## Appeal Decision

**Appeal Ref: APP/R5510/D/20/3259343**

**1 Chelston Approach, Ruislip, Middlesex HA4 9RY**

- The appeal is made under section 78 of the Town and Country Planning Act 1990 against a refusal to grant planning permission.
- The appeal is made by Mr Manoj Shah against the decision of the London Borough of Hillingdon.
- The application Ref 10531/APP/2020/1421, dated 29 April 2020, was refused by notice dated 29 June 2020.
- The development proposed is a single storey front extension, part two storey, part single storey rear extension and two storey side extension.

EXISTING & PROPOSED FRONT AND REAR ELEVATIONS

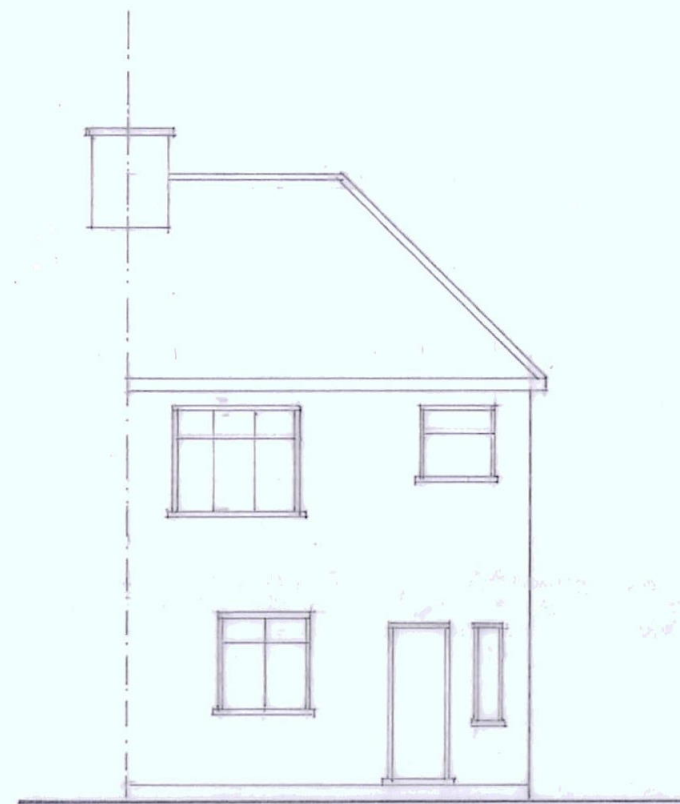
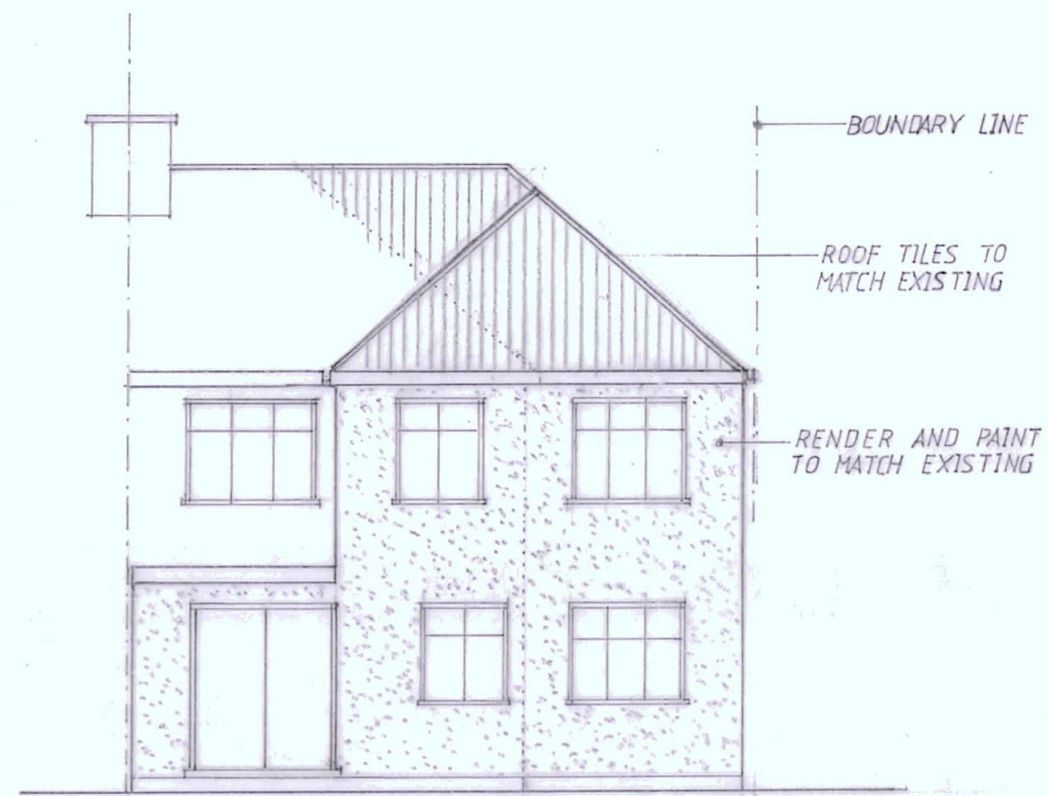
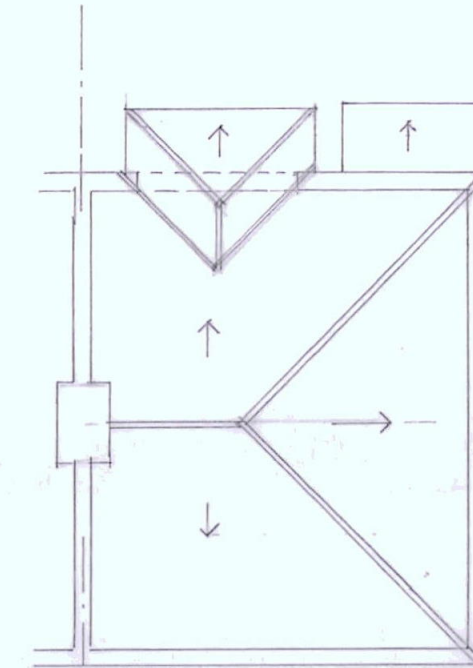
7. Whilst the proposed hipped-roof would not be out-of-keeping with the design of the appeal dwelling or the terrace, it would continue the existing roof ridgeline and so would not be subordinate to the host building. Similarly, the proposed extension would not be set back from the front elevation and would not, therefore, be seen as subservient.

10. The cumulative impact of the scale, massing and position of the proposed development would make it an incongruous and disproportionate addition to the appeal dwelling, which would be readily visible in views from the front and to a lesser extent the rear<sup>2</sup>. Furthermore, in views from the front it would also detract from the balance of the short terrace, to the further detriment of the character and appearance of the area.

EXISTING & PROPOSED SIDE
PROPOSED ROOF PLAN

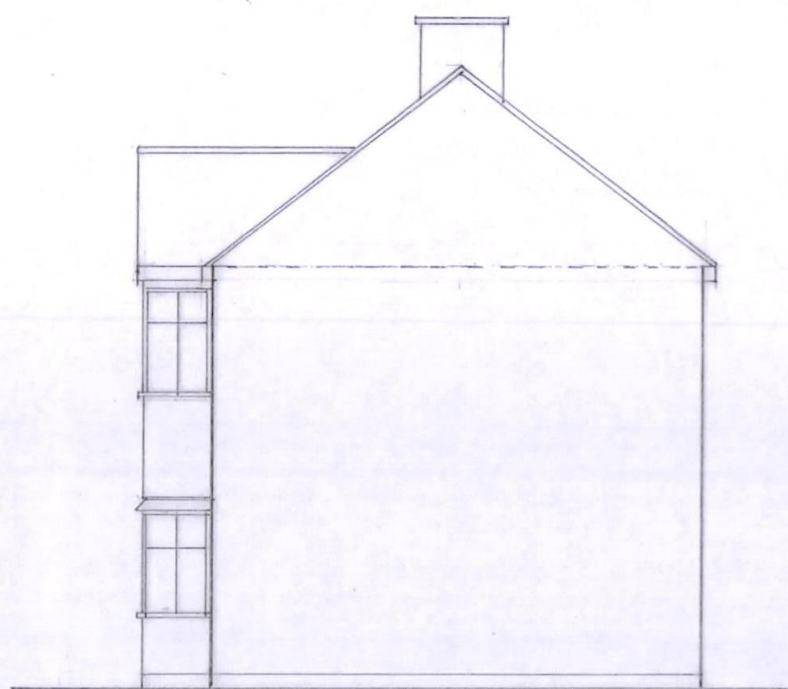
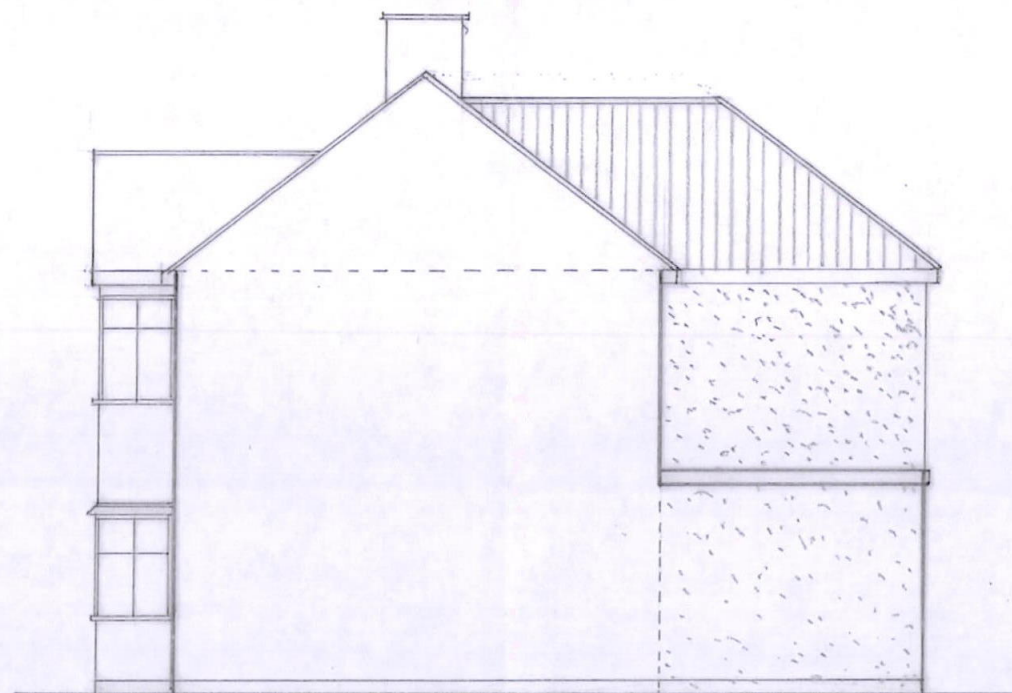
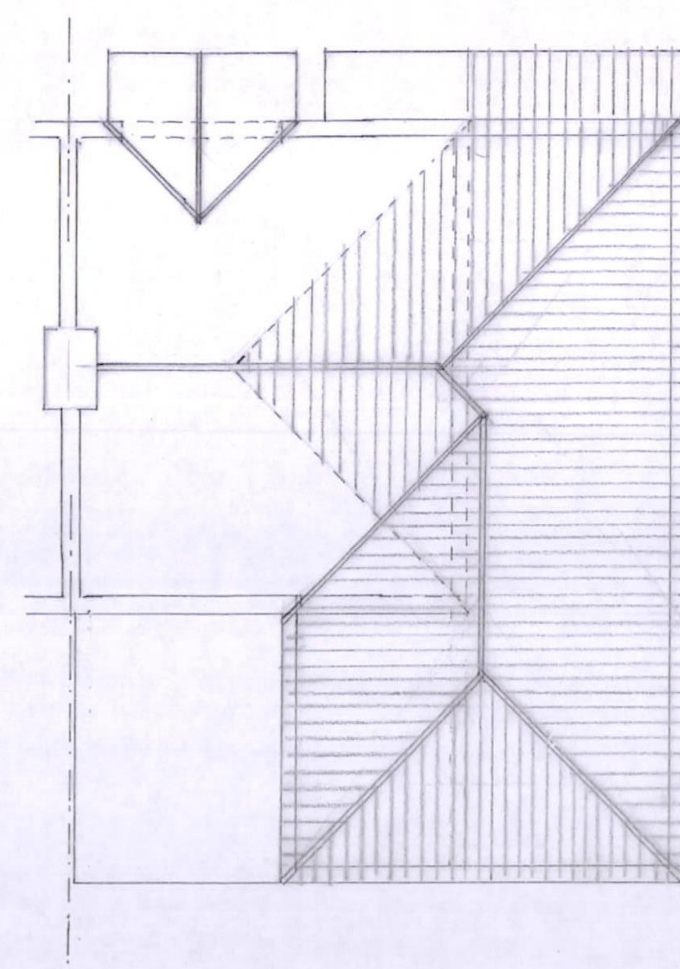
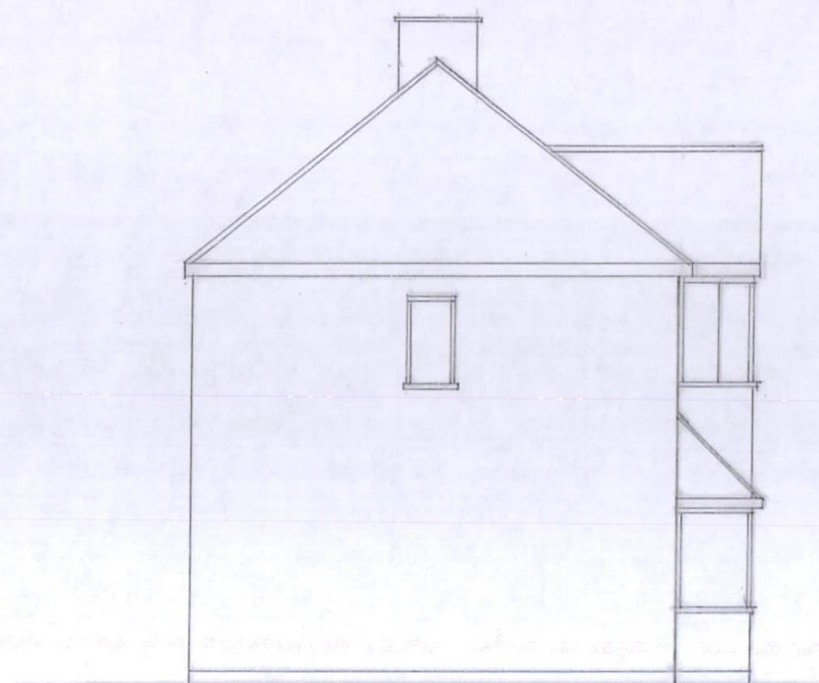
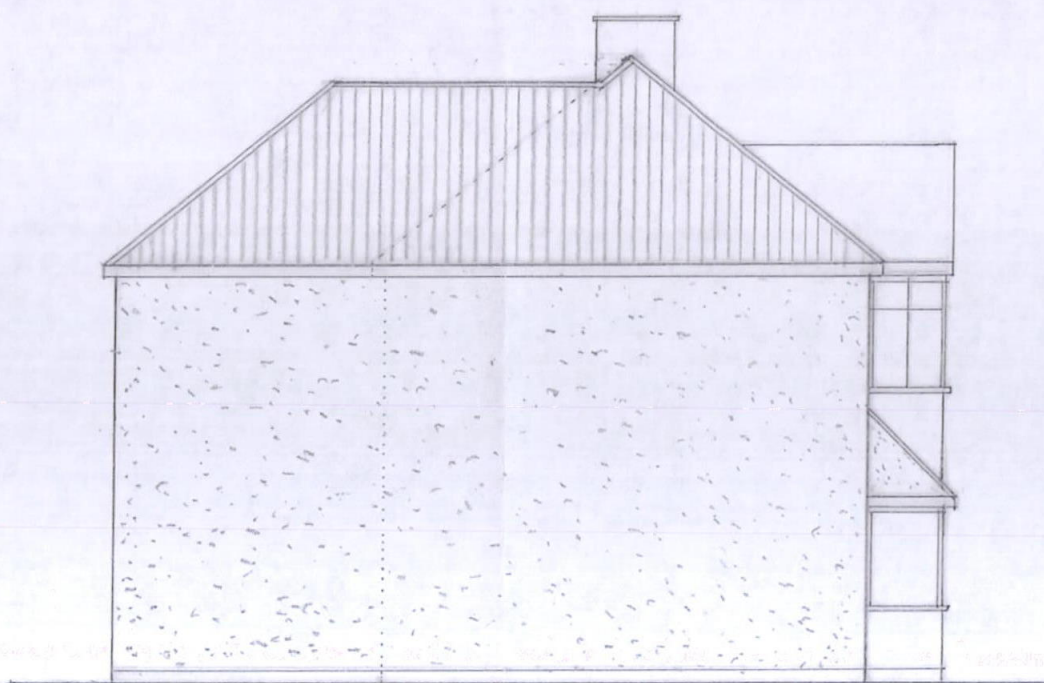
8. The proposal would extend over the existing driveway to the side of the building and would be more than half the width of the appeal dwelling, leaving a gap of only around 150mm between the boundary with the next door commercial property. This would significantly reduce the space between these buildings, creating a somewhat cramped appearance along this part of the street.

9. The appellant refers to the Council's guideline gap being 250mm. I cannot find such a reference in the development plan. However, the development plan<sup>1</sup> does require a minimum gap of one metre to the property boundary for 2-storey side extensions such as this, substantially more than is proposed.
